April 08, 2025

Re: Savio Ridge, Tract N-1-B Watershed Subdivision - Preliminary Plat – **DPM Waiver Request**

WAIVER EXHIBIT

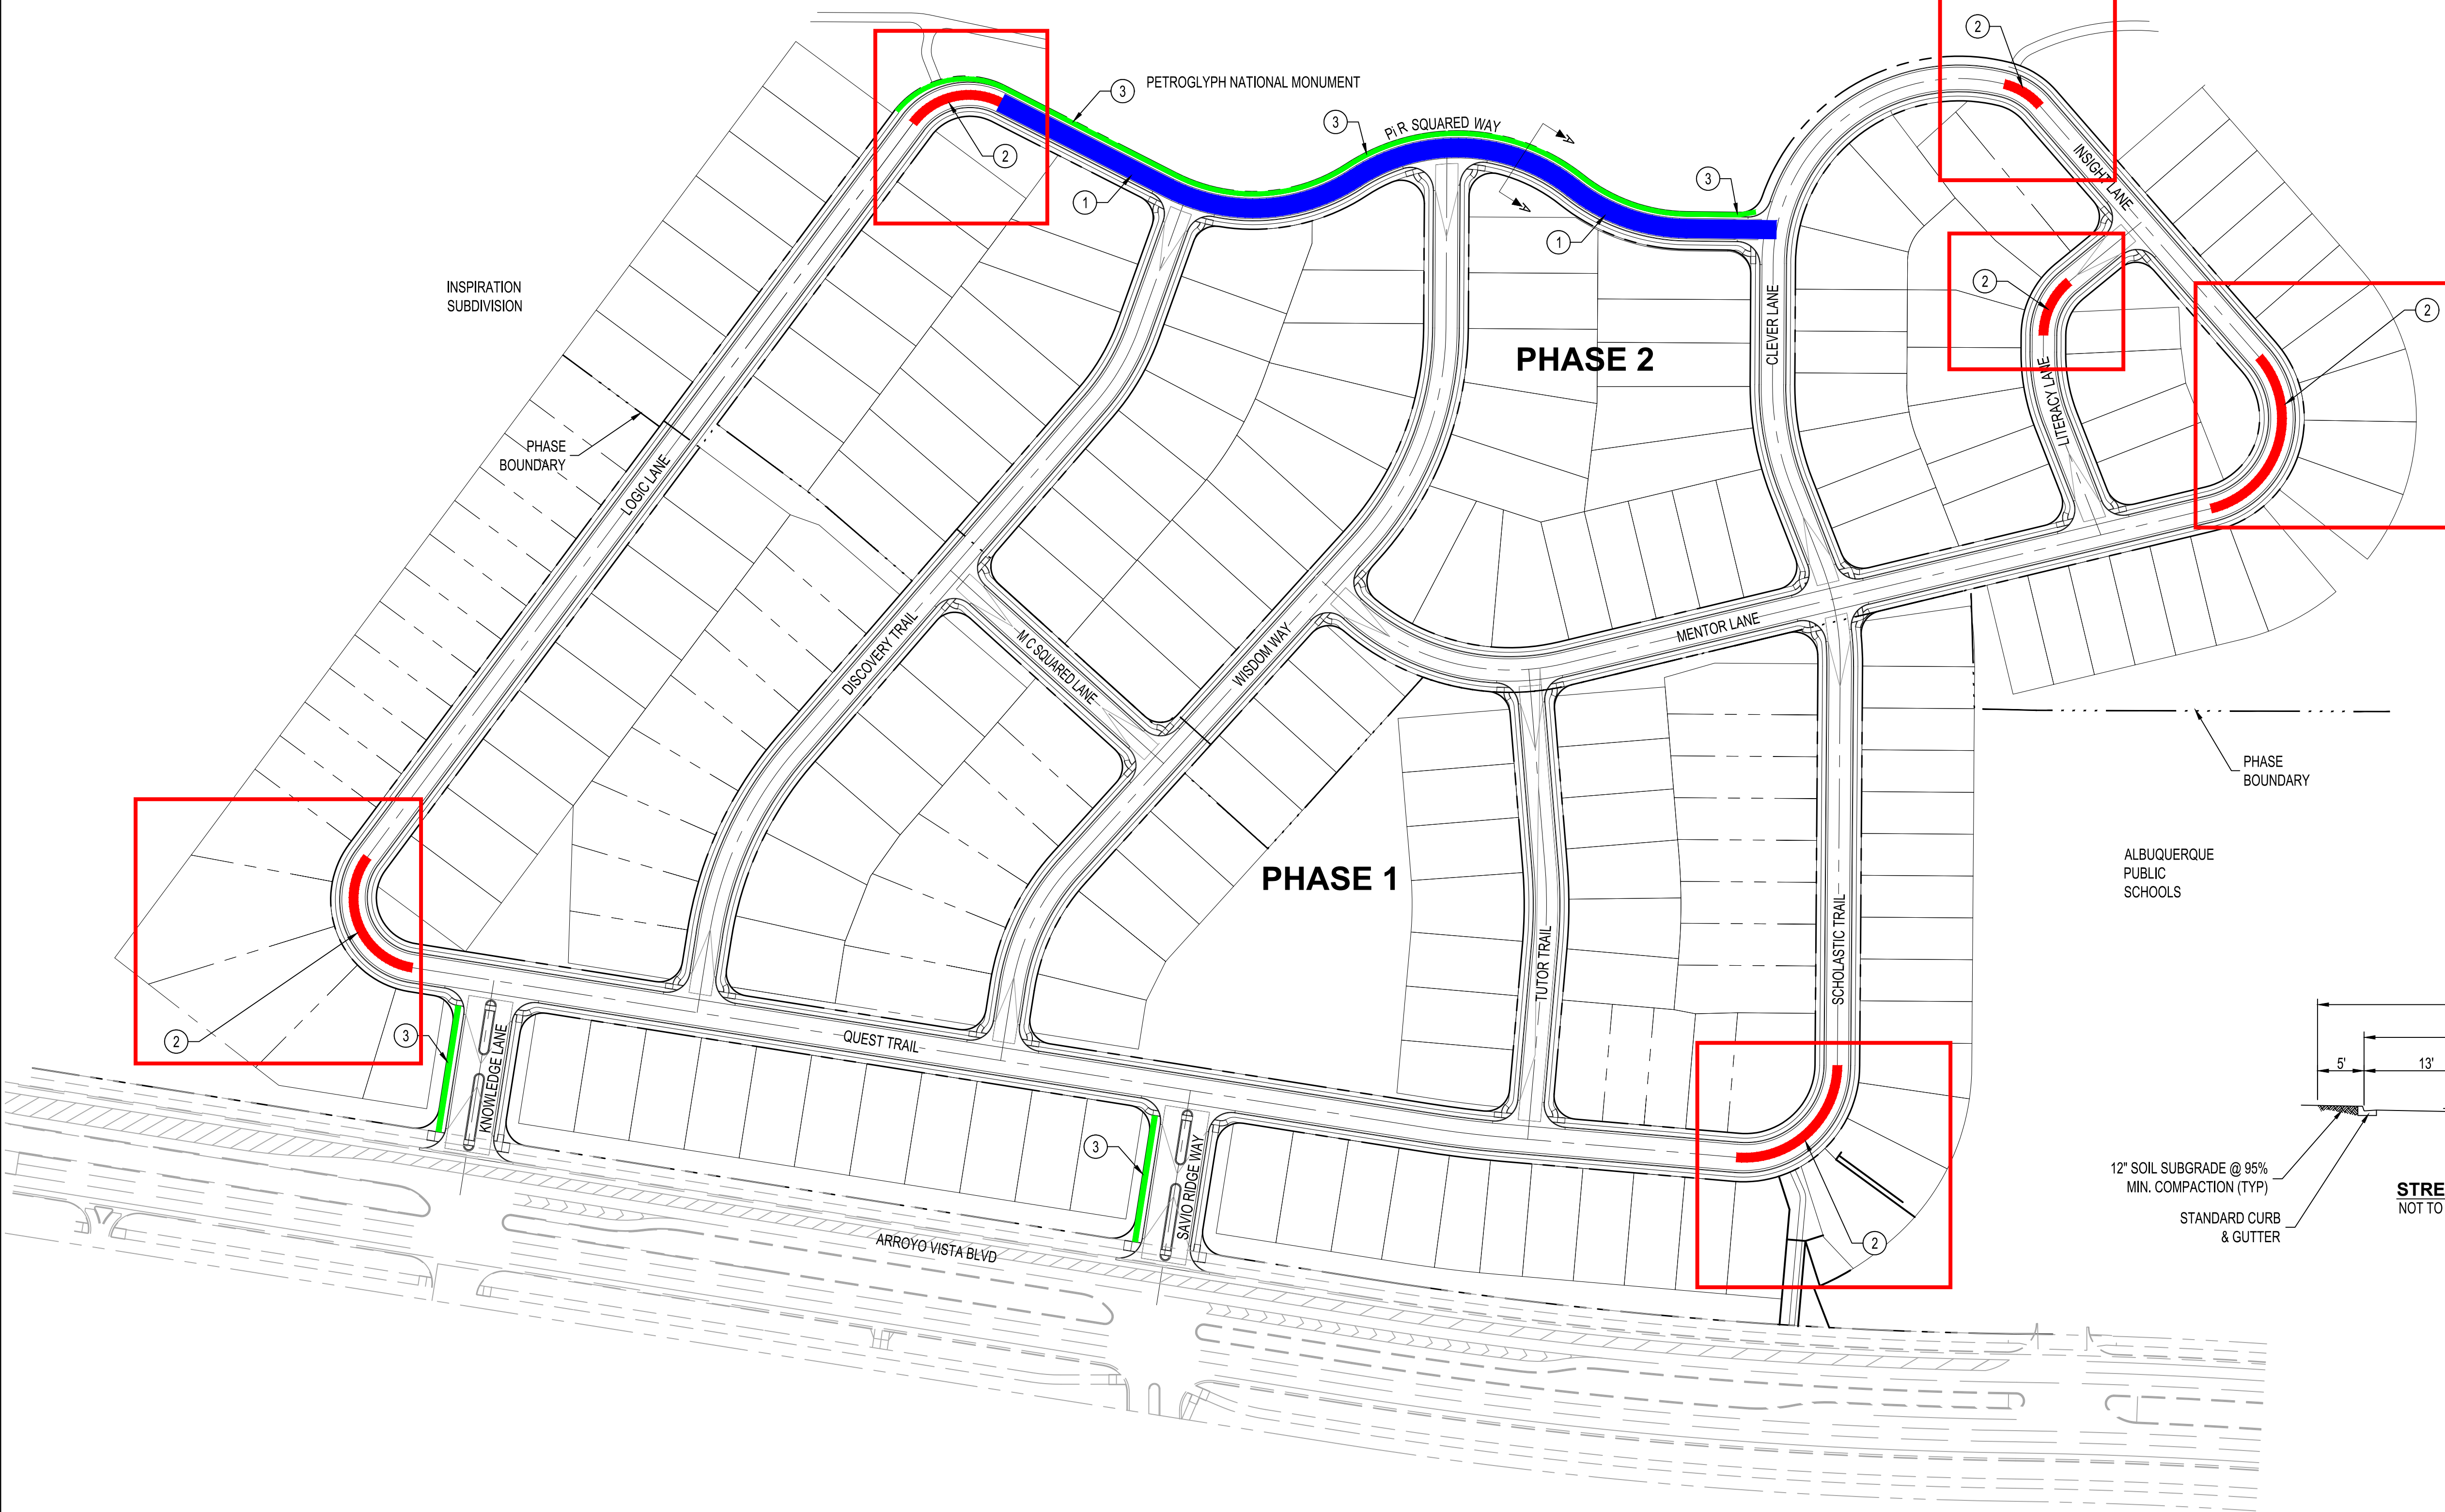
Standard Centerline Radius for a Local Access Street 7-4(l)(2)

- The DPM indicates that “local residential streets with 90 or near 90-degree turns may be designed with a minimum centerline radius of 75’ with the approval of the Traffic Engineer.”
 - There are six locations where there is a 75’ centerline radius, where the road is 90 or near 90-degree. Two are located on Logic Lane, two are located on Insight Lane, one on Scholastic Trail, and one on Literacy Lane. Given that the locations mentioned will have no public thoroughfare the vehicular speeds will be low, allowing for a tighter turning radius.
